Application by Oaklands Farm Solar Limited for an Order Granting Development Consent for Oaklands Farm Solar Park
The Examining Authority's third written questions and requests for information
Issued on Tuesday 12 November 2024

The following table sets out the Examining Authority's (ExA's) third set of written questions and requests for information (ExQ3).

EN010122 - D5 - 13.7 - Indicative Cable
Trench Plan

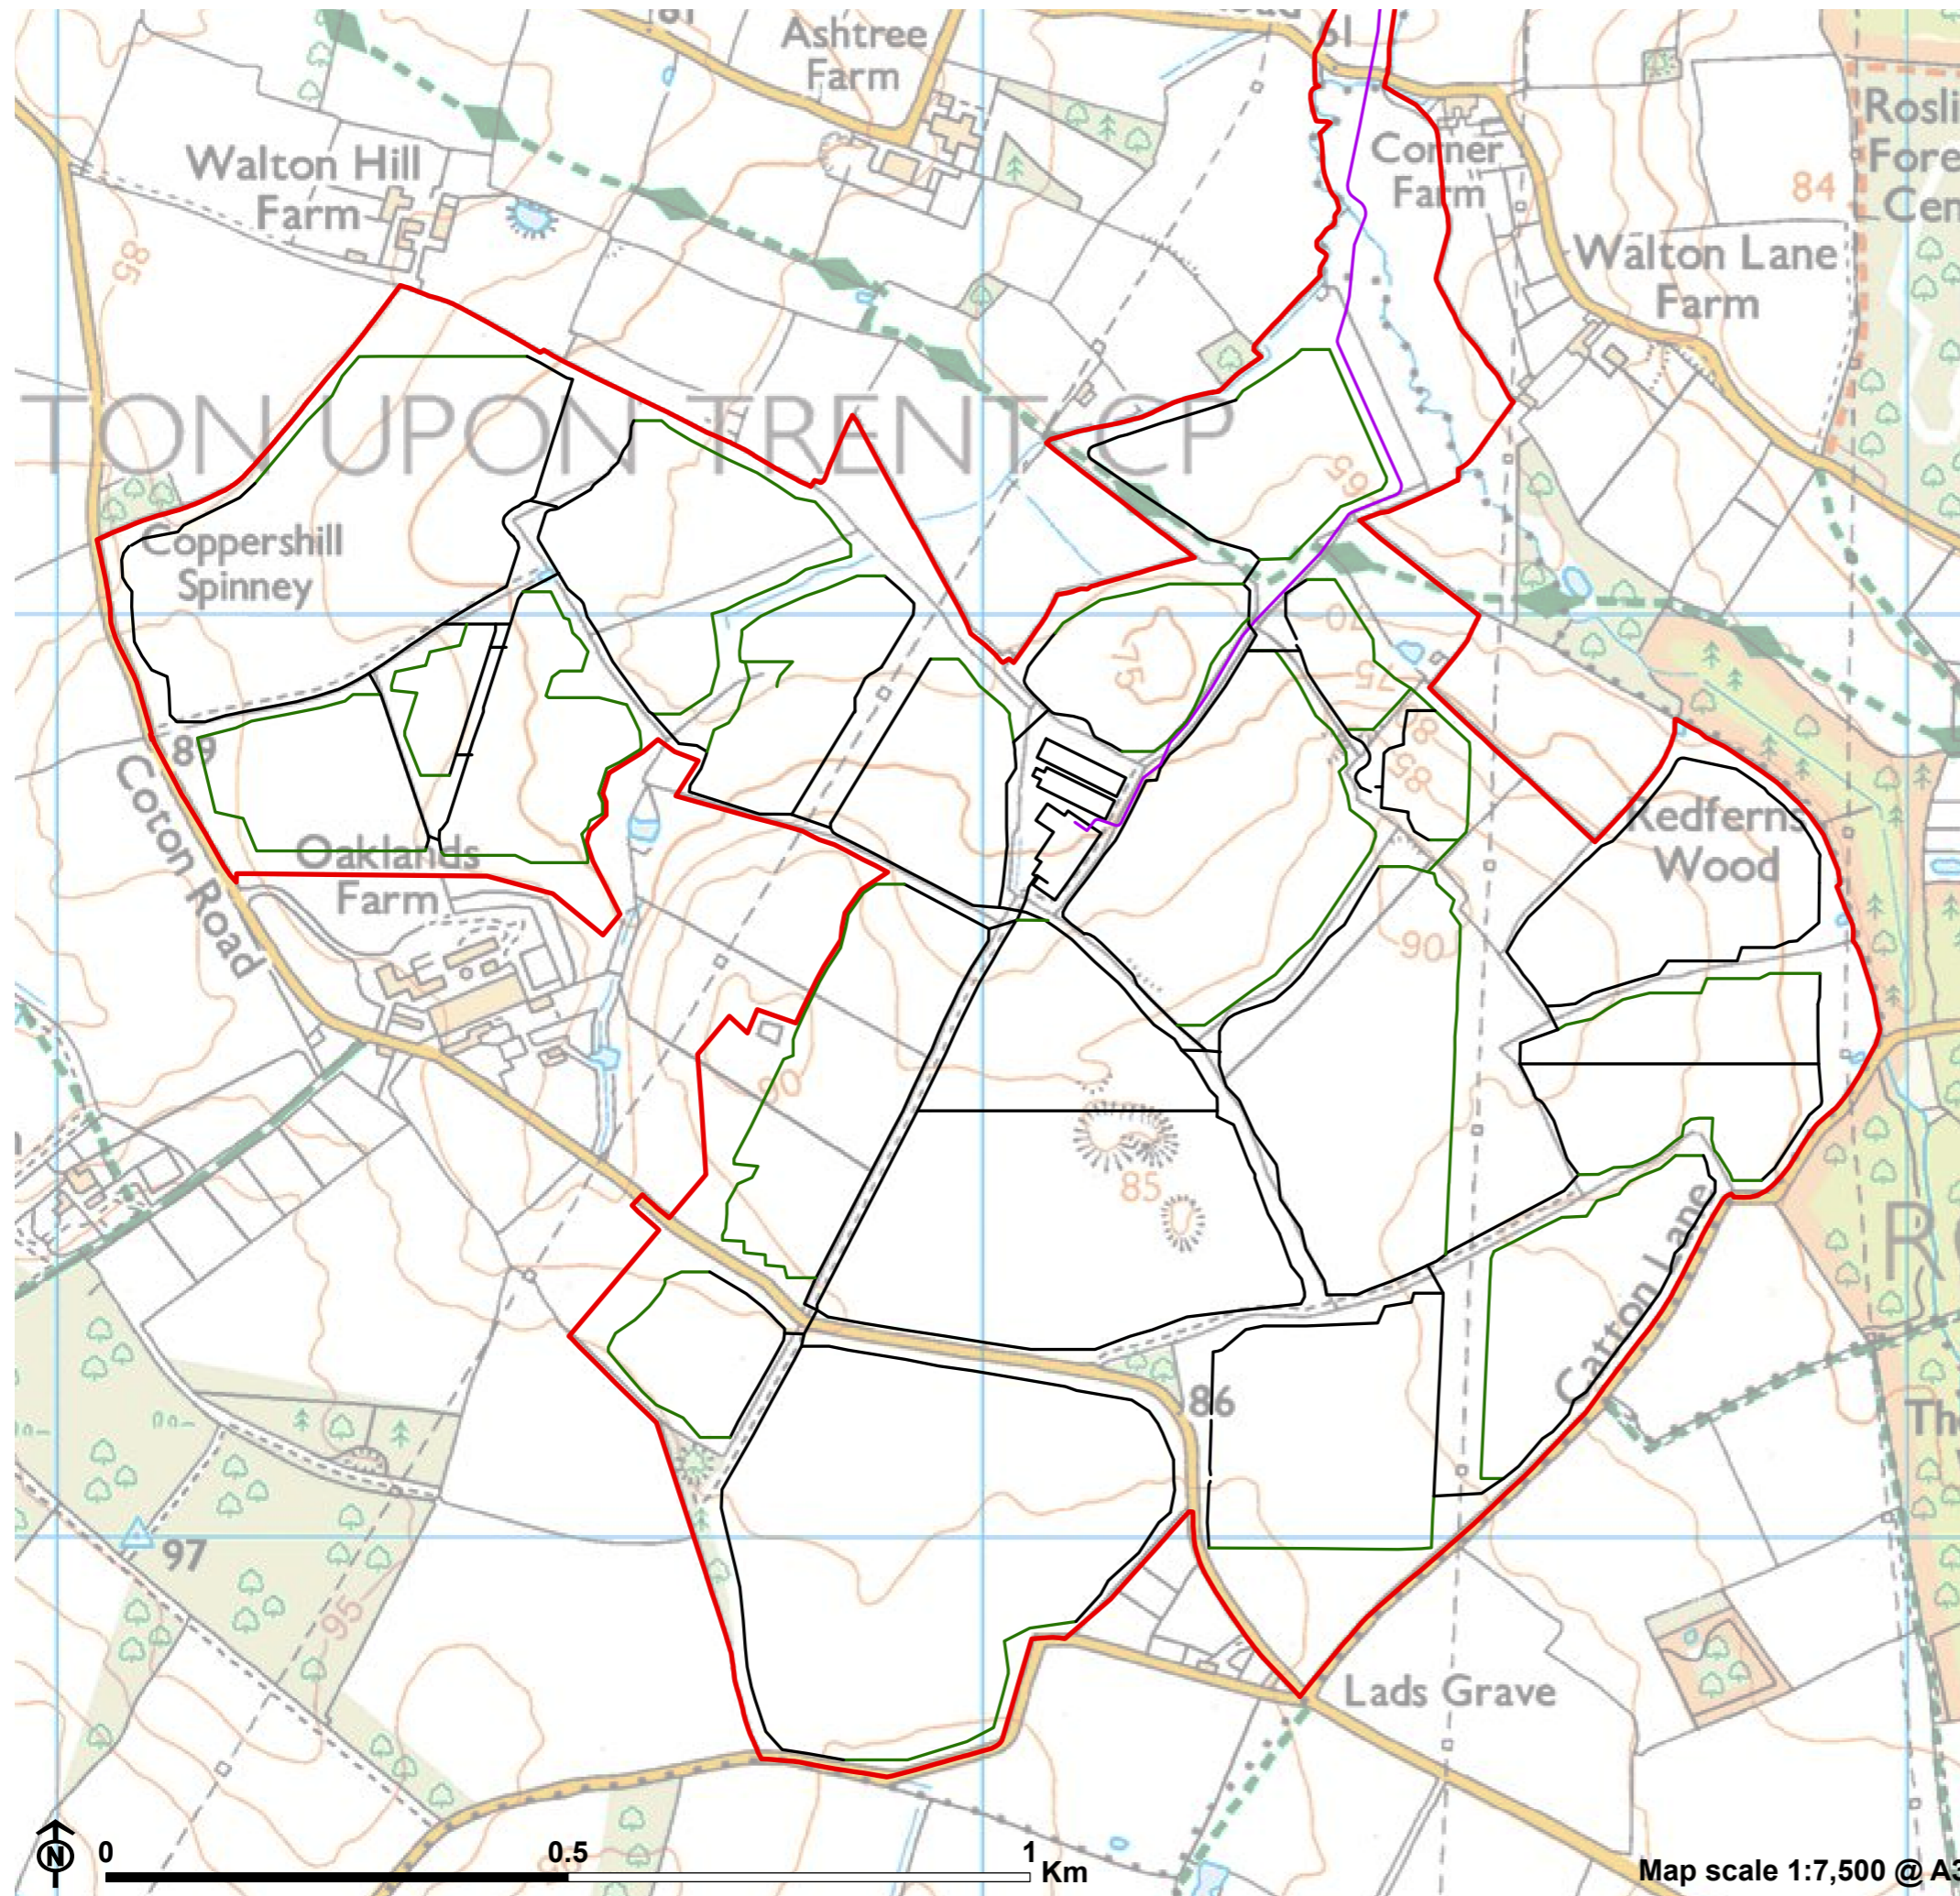
| Ref: | Question to: | Question: |
|------|----------------------------------|--|
| 6.5 | <p>Applicant EA SDDC</p> | <p><u>Decommissioning of underground cables</u></p> <p>The ExA [EV4-002] requested that the Applicant respond to SDDC’s concerns that cables left in place after decommissioning could conflict with future agricultural land uses including in relation to the reinstatement of land drainage.</p> <p>Chapter 4 of the ES [REP5-019] secures a minimum depth of cables of 0.9m, apart from a minimum depth of 0.7m at onsite cabling between PV modules and inverters and from inverters to transformers and the crossing of Coton Road.</p> <p>NE [AS-033] say that “<i>the maximum possible depth of a soil profile is generally considered to be 1.2 m and therefore, the cables may be laid partially within the depth of the natural soil profile, but will be well below the topsoil layer and the minimum depth of cover over the cables is not considered to compromise the ability of the overlying agricultural crops to produce a functioning and effective root system. This depth is expected to be consistent with the industry standard of 0.9m depth.</i>”</p> <p>Paragraph 2.6.9 of the Outline CEMP [REP5-011] includes that “<i>During construction of the Proposed Development, piling of solar panel mounts and / or the installing underground electrical cabling via trenching may result in disturbance or damage to existing land drains. Where this occurs and creates an unacceptable surface drainage issue, other measures (e.g., repairing or installing new land drains) would be available to rectify such drainage issue. Once established, the drainage on-site will be monitored, and drainage measures altered or improved as necessary.</i>”</p> <p>Section 3.1.4 of the Outline DEMP [REP5-015] says that “<i>the Applicant intends to remove buried cables after decommissioning, though will be led by the planning authority and relevant policy in place at the time of decommissioning. The cables may be left in situ, depending on the method which is likely to have the least environmental impact at the time.</i>”</p> <p>Paragraph 1.6 of the Outline SMP embedded in the Outline DEMP [REP5-015] includes that “<i>The Applicant commits to the repair of land drains or the installation of new land drains where removal of solar panel mounts and/or the removal of underground electrical cabling results in</i></p> |
